Office of
Environment
& Heritage

RE: WAMBO COAL MINE (DA 305-7 2003) MODIFICATION 11 – MONTROSE WATER STORAGE DAM

COMMENTS AND RECOMMENDED CONDITIONS OF APPROVAL FOR THE PROPOSED MODIFICATION 11 FOR THE WAMBO COAL MINE

Figure 3 - Proposed layout of Montrose East Dam

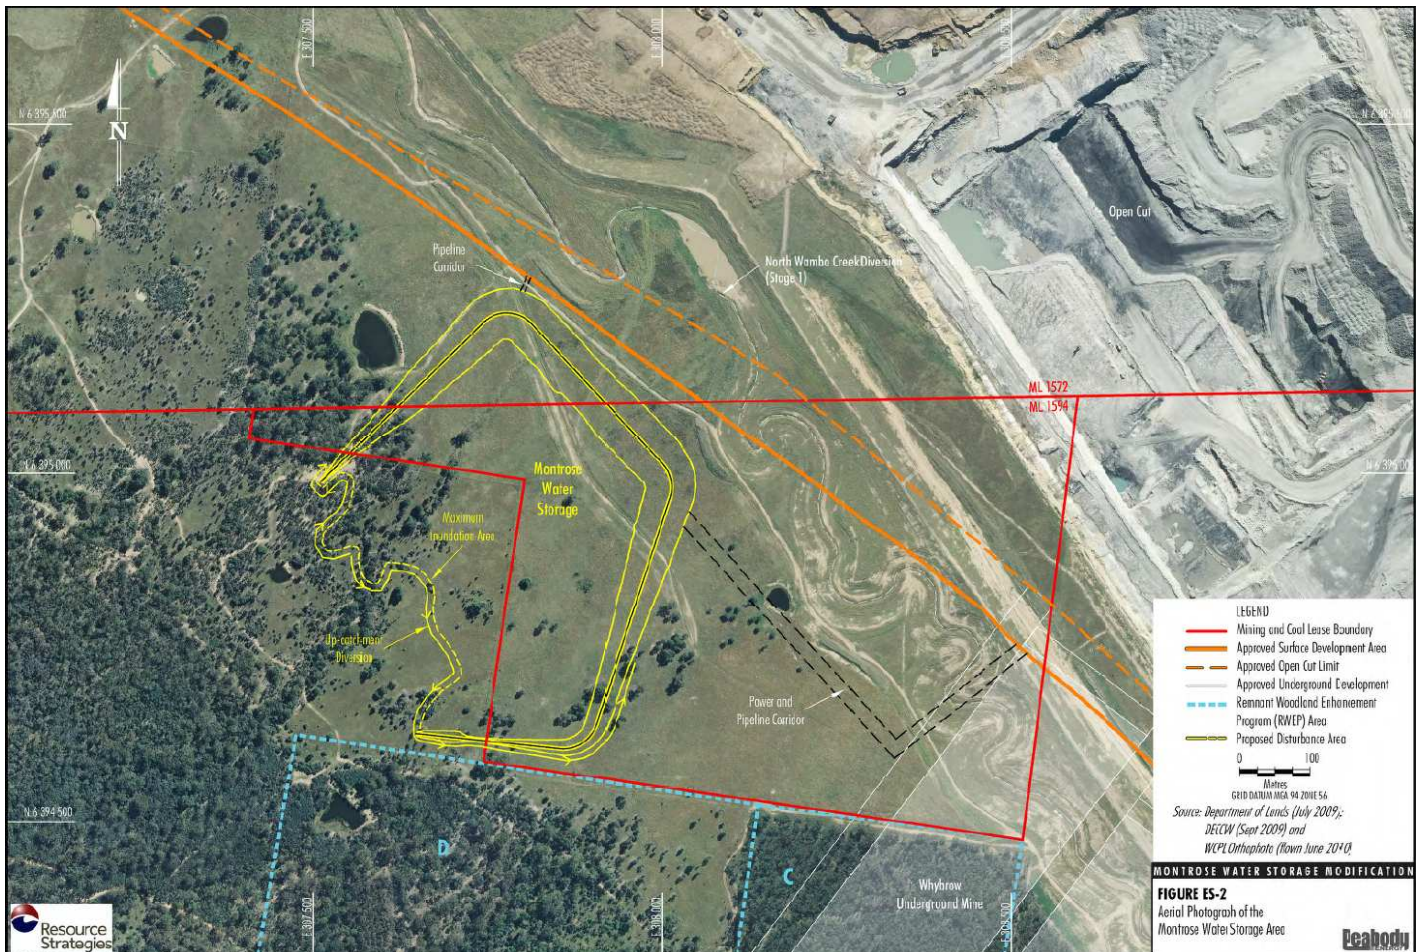
The proposed Montrose Storage Dam would be a turkey-nest style dam with a footprint of about 24 ha. It would require supporting infrastructure including pumps, pipes and powerlines.

OEH also notes that the proposed development would clear about 1.8 ha of Central Hunter Box – Ironbark Woodland Endangered Ecological Community and about 0.8 ha of Narrabeen Foothills Slaty Box woodland Vulnerable Ecological Community (EA, pg. 28). OEH acknowledges that this is a small area, however, the EA does not propose any mitigation measures for this loss of threatened plant communities. This is not appropriate and therefore OEH recommends that the provision of an appropriate biodiversity offset for this loss is required as a condition of approval (see below).

1. That the clearance of threatened species, populations or communities, or their habitats, for this development must be offset in accordance with OEH offsetting policy; either the 'Principles for the use of biodiversity offsets in NSW' (DECC, 2011) or the 'NSW OEH interim policy on assessing and offsetting biodiversity impacts of part 3A, State significant development (SSD) and State significant infrastructure (SSI) projects (OEH, 2011).
